Ribble Valley Borough Council
Housing & Development Control

Application no: **3/2024/0361**

Address: **2 George Street Whalley BB7 9TH**

Proposal: Demolition of utility room, garage and wall to front garden. Construction of two-storey extension to side and rear, single-storey extension to side, new double garage to rear and new vehicular accesses to front and rear, including parking spaces for two cars.

PROPOSED GARAGE PLAN
& ELEVATIONS

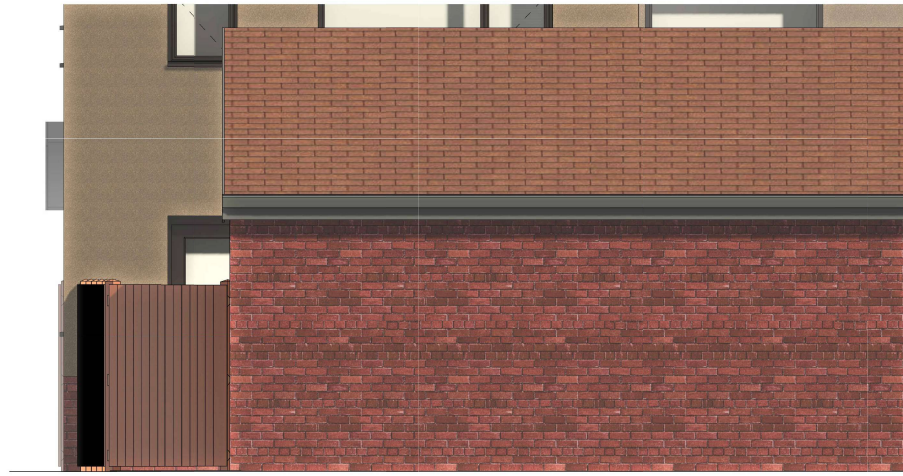
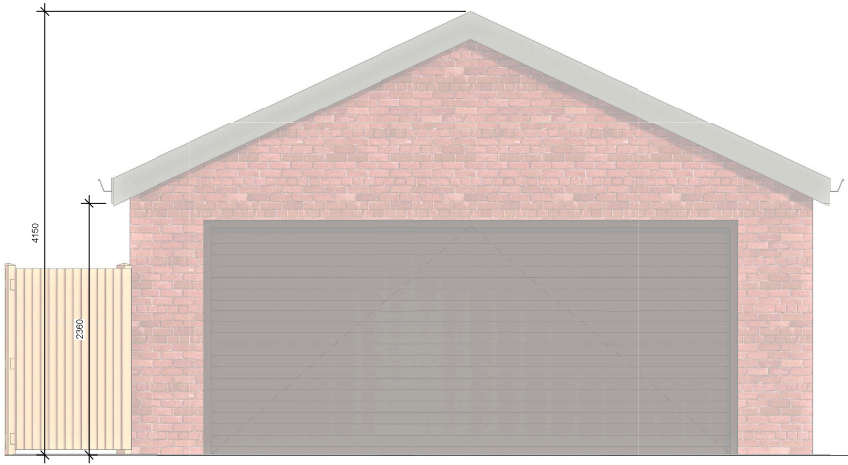
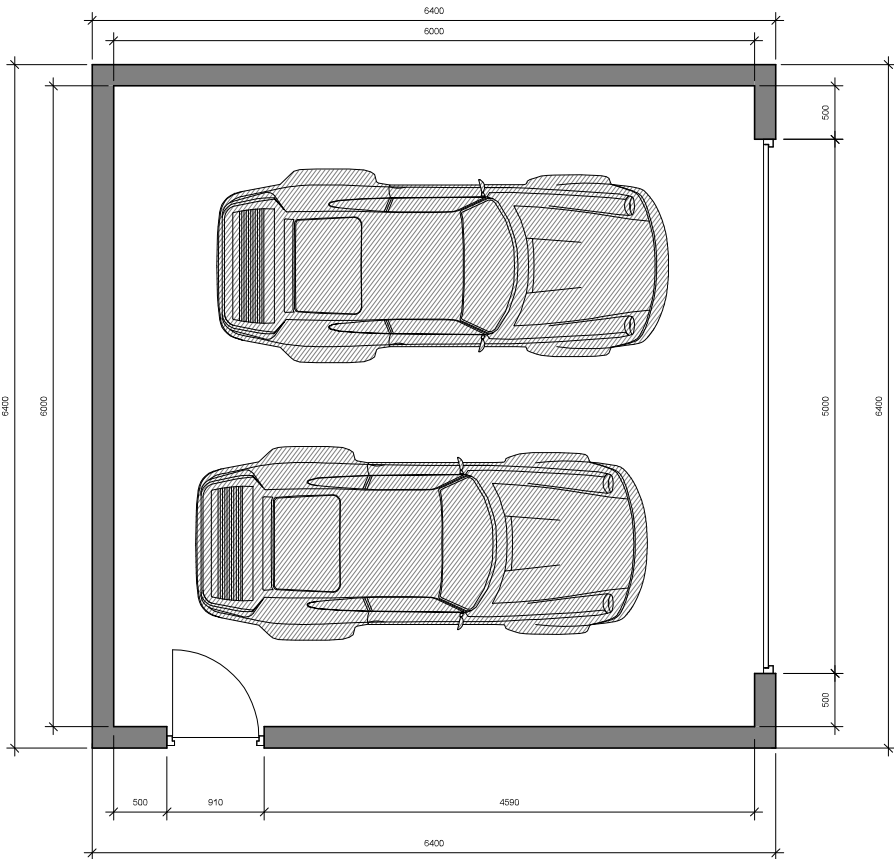
Furthermore, as part of the proposal, a new double garage will be provided at the rear of the dwelling, following the demolition of the existing garage. The proposed double garage, like the existing, will be accessed from the unadopted access track located at the rear of Numbers 71 to 97 King Street. Given the proposal is replacing an existing garage, the LHA have no comments to make.
